**KIRKLEES METROPOLITAN COUNCIL
INVESTMENT & REGENERATION SERVICE**

DELEGATED DECISION TO DETERMINE PLANNING APPLICATIONS

Reference No:	2025/62/91168/E
Site Address:	Wilton Mills, 586, Bradford Road, Batley, WF17 8LP
Description:	Demolition of existing garage and erection of MOT bay/service area (within a Conservation Area)
Recommending Officer:	Edward Cheseldine

DECISION - Refuse

PROPOSED SOUTH EAST ELEVATION, SCALE 1:100

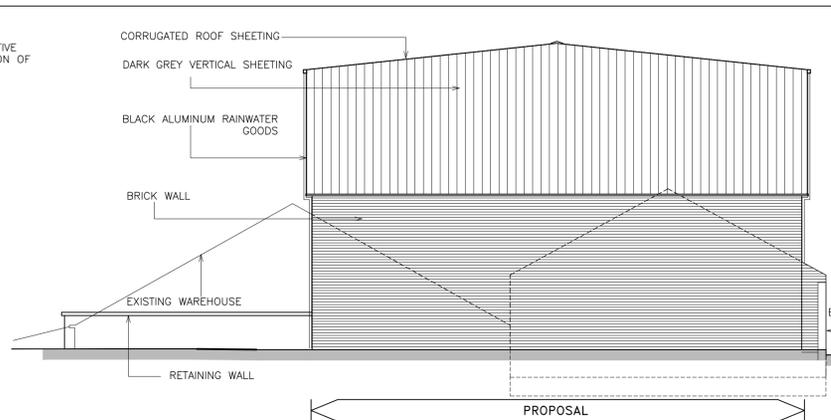
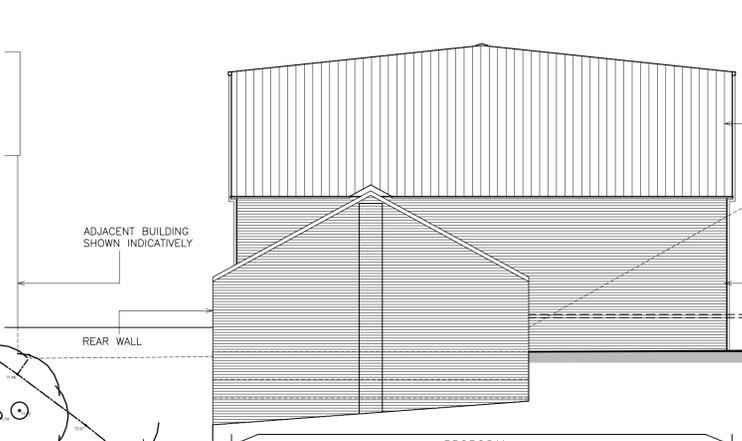
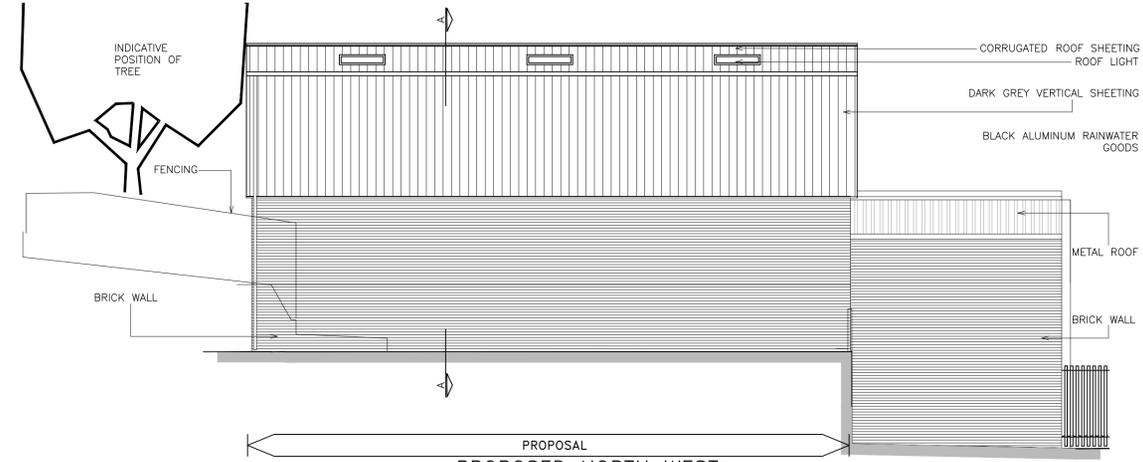
The servicing building will be 17.00m(w) x 14.20m(l) with an eaves height of 7.90m and a ridgeline height of 8.70m. The building will be constructed with brick course and dark grey metal vertical with a corrugated metal sheet roof. 3 large roller shutter which have a height of 4.30m will be installed on the south-east facing elevation.

Plans indicate the side elevation would be 4.15m above the Wilton Mills buildings to the south-west of the site due to ground level changes.

This application therefore seeks an increase in size, scale and height of the MOT building. Increasing the width by 4.20m, length by 0.60m and the height of the building by 2.20m. Due to ground level changes, the proposed building would appear taller and more visible than the existing adjacent building. It would appear visible by 4.15m whereas the building pursuant to 2022/93360 would be 1.30m taller.

The addition of the proposed building is set at a much greater height than surrounding buildings including the tram depot and worker houses. It would draw the eye away from these buildings even when viewed from medium and long distances. Aspects along Carlinghow Hill include vantage points of the building from a short distance, resulting in a near total loss of connection with the rest of the conservation area due to its dominating presence. The

connection between worker houses and development would be lost. A change in material to stone or brick side would not harmonise the development with the conservation area when considering the height, bulk and roof form which only extenuates the harm to the special interest/setting of the conservation area.

In comparison to the building previously approved under application 2022/93360, the building has a greater prominence within the conservation area. It will appear 4.15m above the tram depot due to the increase in height and changes to the ground level. In addition, there is additional mass due to the increase in length and changes to the roof form. Permission 2022/93360

related appropriately to the surrounding building group, setting the approved building in a relative height to the adjacent buildings, being sunk into the landscape. This application, however, competes with the surrounding buildings and the increase in vertical mass and scale would appear at odds with the surrounding built form in the conservation area.

The structure rises well above the roof height of the two-storey buildings present on Carlinghow Hill. The visual presence of the building, when considered from street level, appears stark and intrusive. From medium

distances, south of the site, the building appears to dwarf buildings that line Bradford Road. The shape of the building fails to consider the style of pitched roof shapes that are present within the area, appearing visually jarring. A residential garden sits adjacent to the north-west of the site. The structure will appear above this area, highlighting its scale in consideration of the wider townscape and landscape. Its scale and vertical massing fail to consider the valley landscape and the views possessed throughout the area. In addition, the proposed materials will create a utilitarian appearance which only adds to the contrast between residential development and the modern commercial property.

The proposal therefore fails to harmonise with the surrounding townscape and landscape by virtue of its scale, height, massing, roof shape and materials, appearing stark when considering the terrace row on Carlinghow Hill and buildings on Bradford Road, therefore failing to accord with Policy LP24 of the Chapter 12 of the NPPF.

PROPOSED BLOCK PLAN (SHOWING INDICATIVE DRAINAGE PLAN), 1:1200

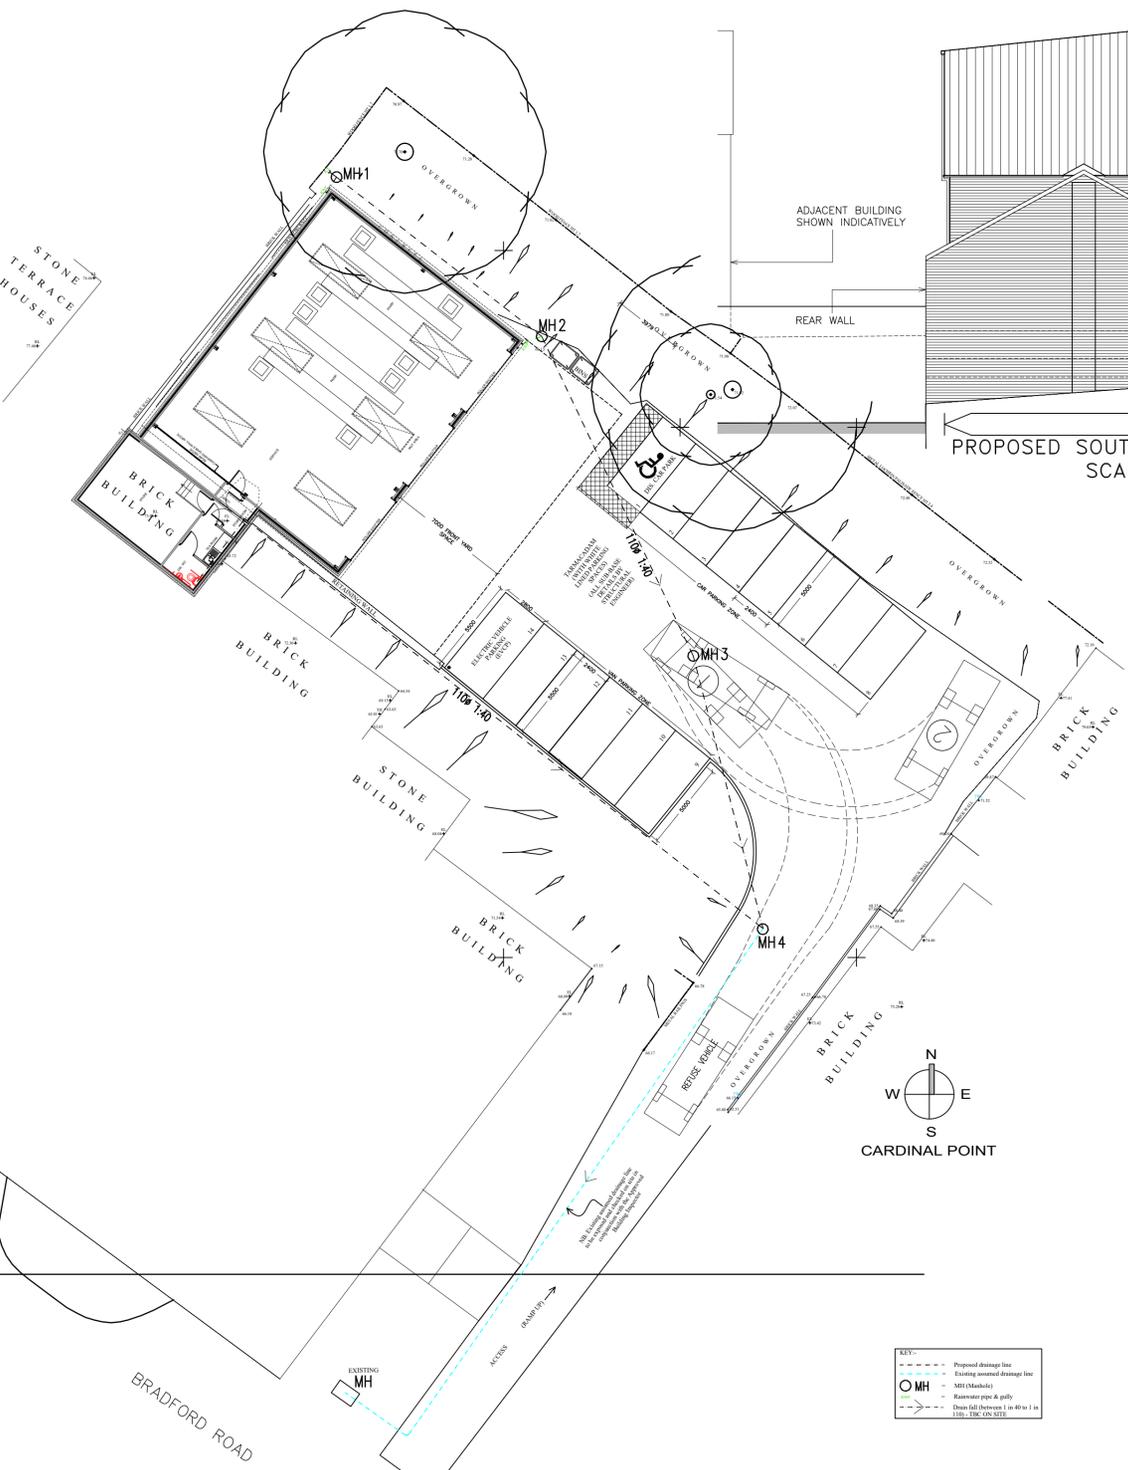
The wider site will include the formation of a car park with 14 spaces, surfaced with tarmac.

The application proposes a courtyard area to the front of the building with provisions for 14 car parking space. The area will be surfaced with tarmac and parking bays marked with white lines. Plans indicate a movement of a vehicles with a length of 7.70m.
